October 15, 2025

**Re: Paradise RV Park (aka Birdie RV Park) Phase 2 at 221 Leonidas Ln NW
Erosion and Sediment Control Plan – K08E003 – (SWQ-2025-00046)
Engineer's Stamp Date: 10/2/2025**

James D. Hughes, P.E., CPESC
Principal Engineer, Planning Dept.
Development and Review Services

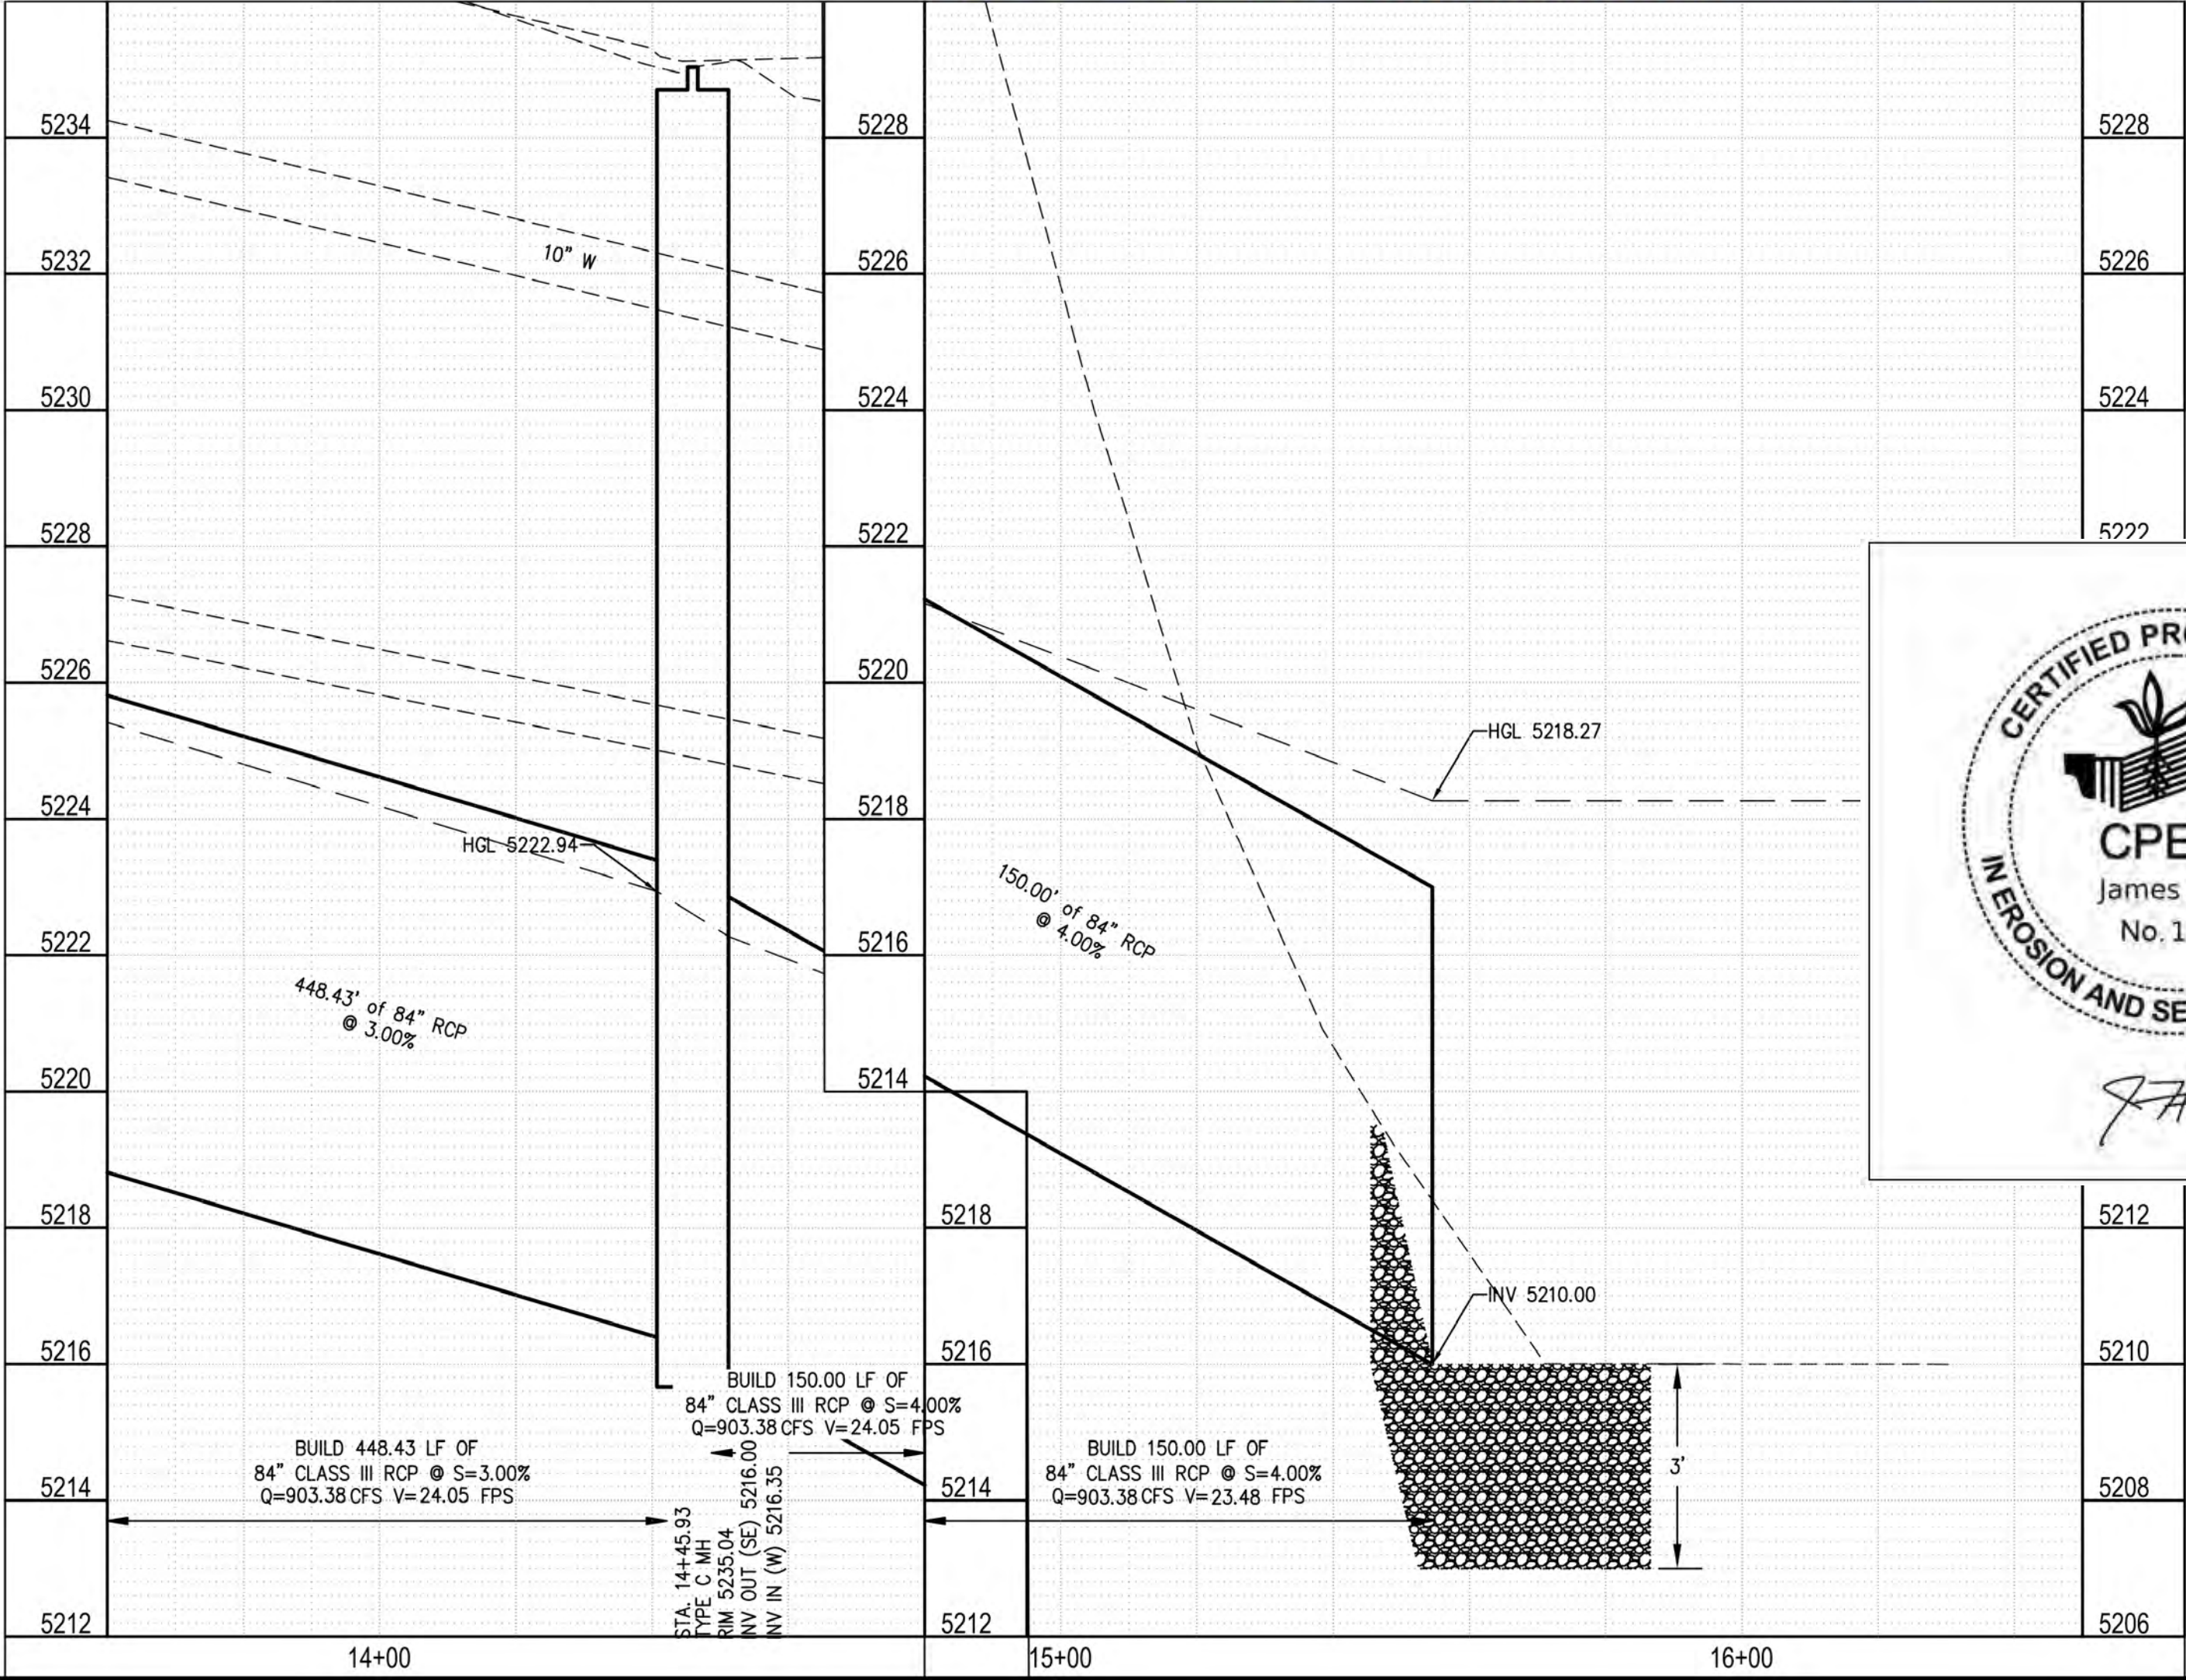
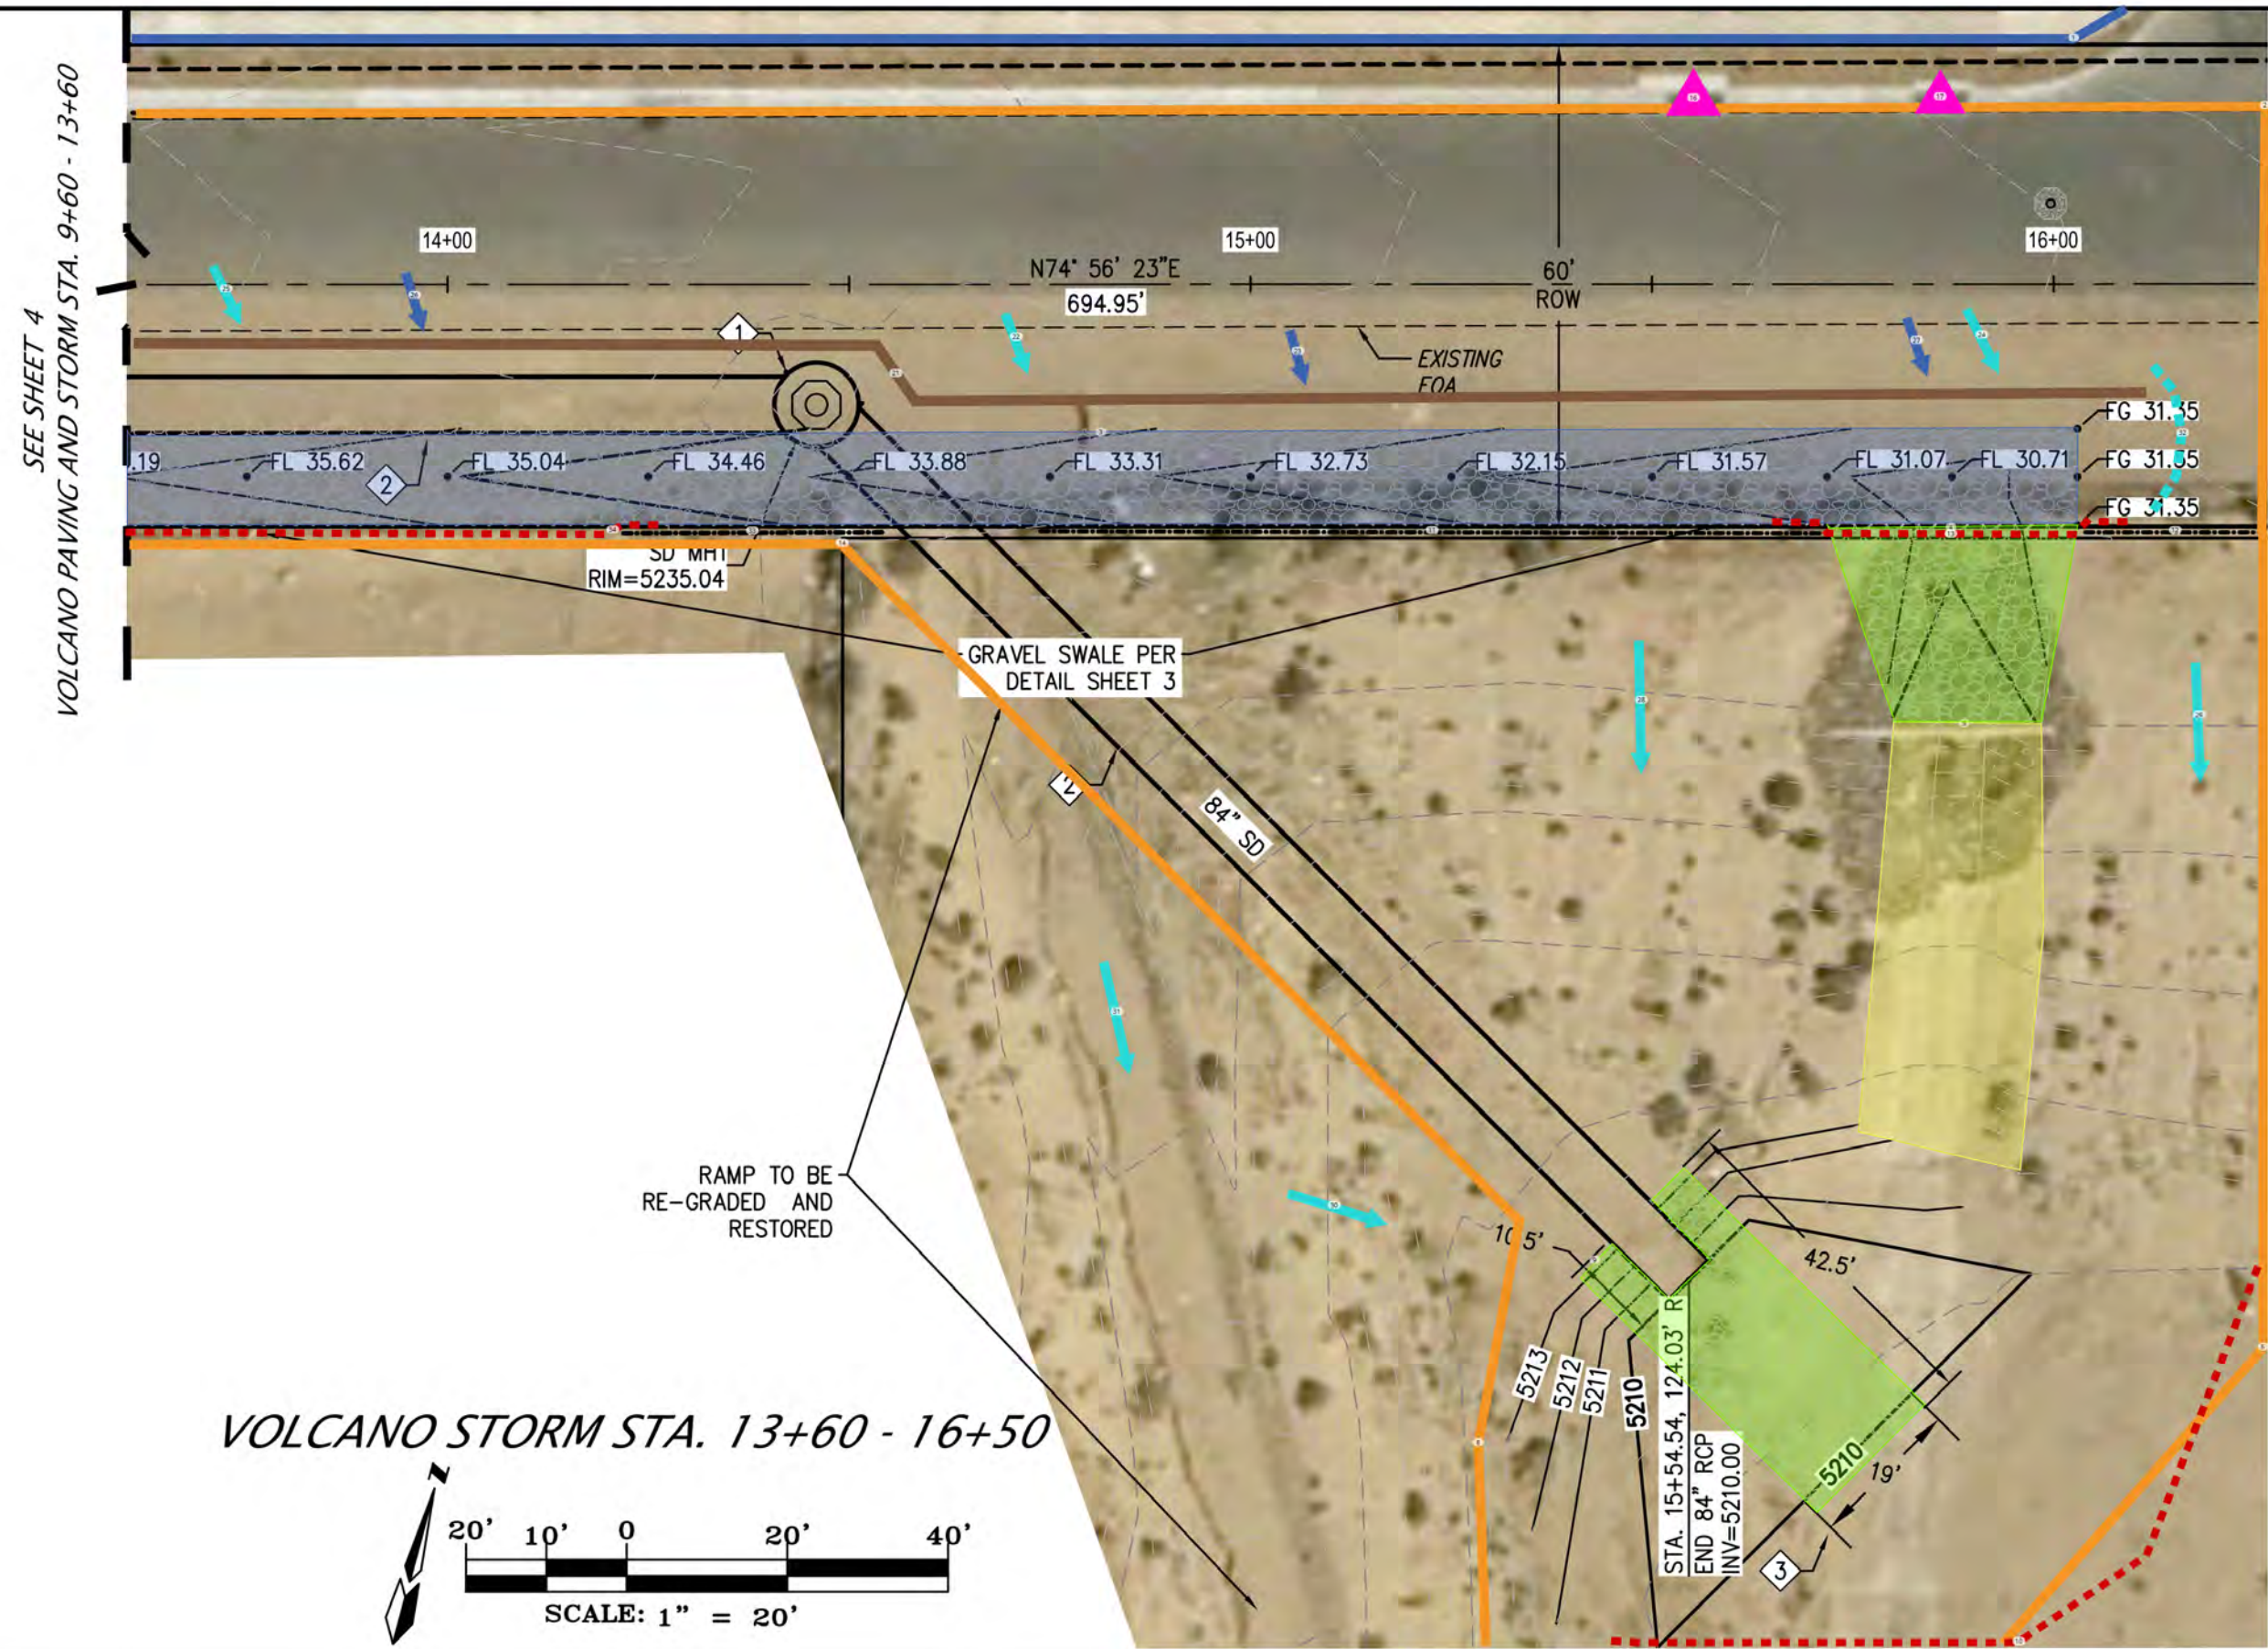
1. The construction support activities west of 102nd St. are not shown on the ESC Plan. Include the limits of disturbance around the 3000 CY hole west of 102nd on the ESC Plan as construction support activities directly associated with this site. Clarify the final plan for the disturbed area, including the schedule and details for final stabilization. Will the hole be filled or left open after construction is completed? Since approximately 3000 CY of grading west of 102nd St. is in Bernalillo County's jurisdiction, provide documentation showing that it is acceptable to them. Also, submit the off-site pond design to City Hydrology if the pond west of 102nd St. affects the existing, interim, or final drainage plan.

2. The extent of repairs needed to fix damages to the city pond has been greatly underreported and misrepresented on the ESC Plan. Phase 2 construction started over a year ago without BMPs. It diverted off-site flows into the pond, which caused severe erosion of the pond maintenance road and significant sediment buildup at the pond bottom. Clearly define the construction limits inside Pond NE2 on a Remediation Plan to be included in the G&D, WO, and ESC Plans. The remediation Plan must include: areas damaged by erosion on the access ramp, sediment accumulation at the pond's bottom, restoration of the damaged low-flow channel between the inlet and outlet at the pond's bottom, and reconstruction of the fence and gate that fell into the erosion hole. Details and specifications for public infrastructure repairs and stabilization should be shown on a Remediation Plan submitted to hydrology, then incorporated into the Work Order (WO) Plans to manage materials, testing, and inspections. Any additional damage to the pond during work order construction is expected to be repaired and should be documented on the Remediation Plan.
